OXFORDSHIRE COUNTY COUNCIL'S RESPONSE TO CONSULTATION ON THE FOLLOWING DEVELOPMENT PROPOSAL

Application no: 23/03073/HYBRID

Proposal: In FULL, the construction of an 82-apartment affordable extra care home (C2 use class) with associated openspace / green infrastructure, landscaping, car / cycle parking, service infrastructure (drainage, highways, lighting), engineering operations, creation of new vehicular access and re-instatement of existing access to footpath, and in OUTLINE, the construction of up to 14 residential (C3 use class) dwellings with associated landscaping, service infrastructure (highways, drainage, lighting)

Location: Phase 2 SW Bicester Kingsmere Parcel R East Of, Ludlow Road, Bicester

Appendix C – Proposed Site Layout

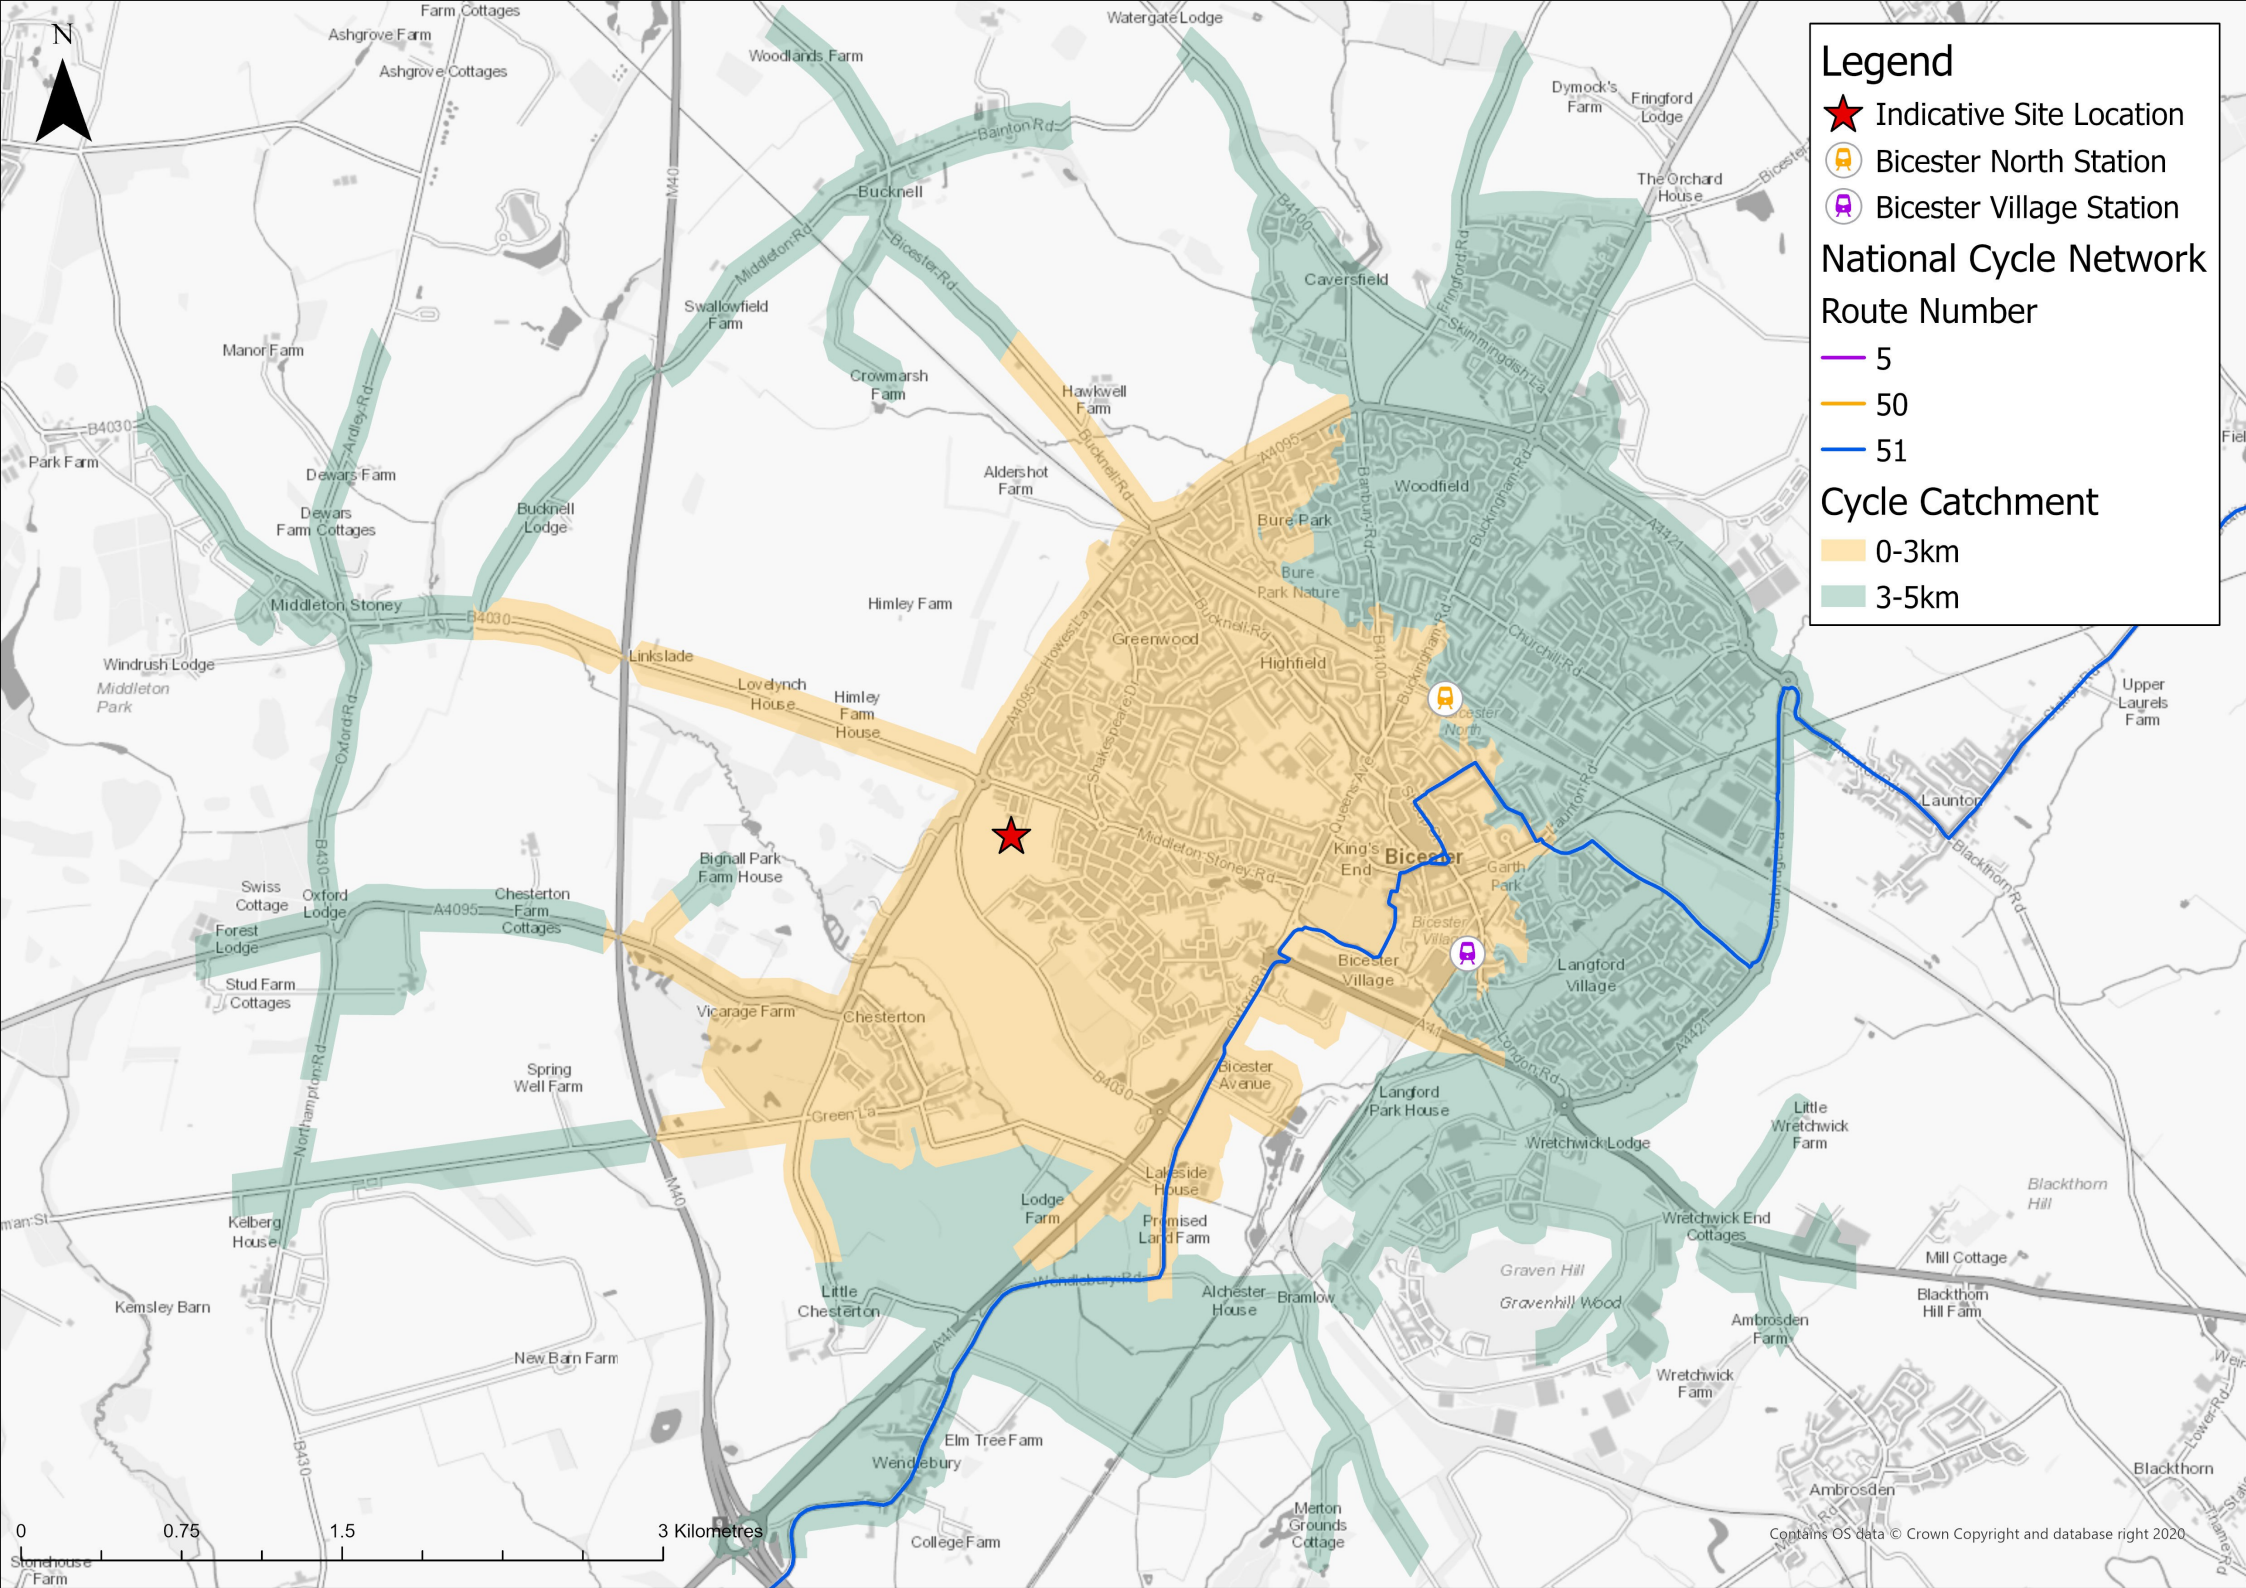
Detail of cycle parking facilities should be suitably conditioned and should be provided in accordance with current OCC policy and LTN 1/20 standards. However, the application should at this stage demonstrate on fully dimensioned plans that there is sufficient space / footprint in order to adequately provide the number of cycle parking facilities proposed (this should include e-bikes and provision for adequate charging facilities). The cycle parking seems only designed for standard bikes. Given the nature of the development, this needs to accommodate a wider range of cycles. Provision for the storage and charging of mobility scooters has not been clarified on plan.

The bicycle parking facilities should be located in a fully accessible location and closer to the main access points of the development with a clear path available.

The dimensioned site layout plan indicates some aisle widths of 4.63m near turning paths which is narrow for two-way vehicle movements. Safe two-way vehicle movement has not been demonstrated.

Permeable access should be facilitated with no access barriers used as they act as obstacles to disabled, vulnerable users as well as non-standard bikes.

Although the required safe visibility splays appear to be contained within the public highway there appears to be possible obstructions within it (e.g. shrubs / wall). The visibility splay should be free of obstructions 2m high down to a point 600mm above the carriageway. Trees should not be positioned within visibility splays. It is noted that the applicant is willing to address this issue by ensuring that there is no obstructions within the visibility splays.
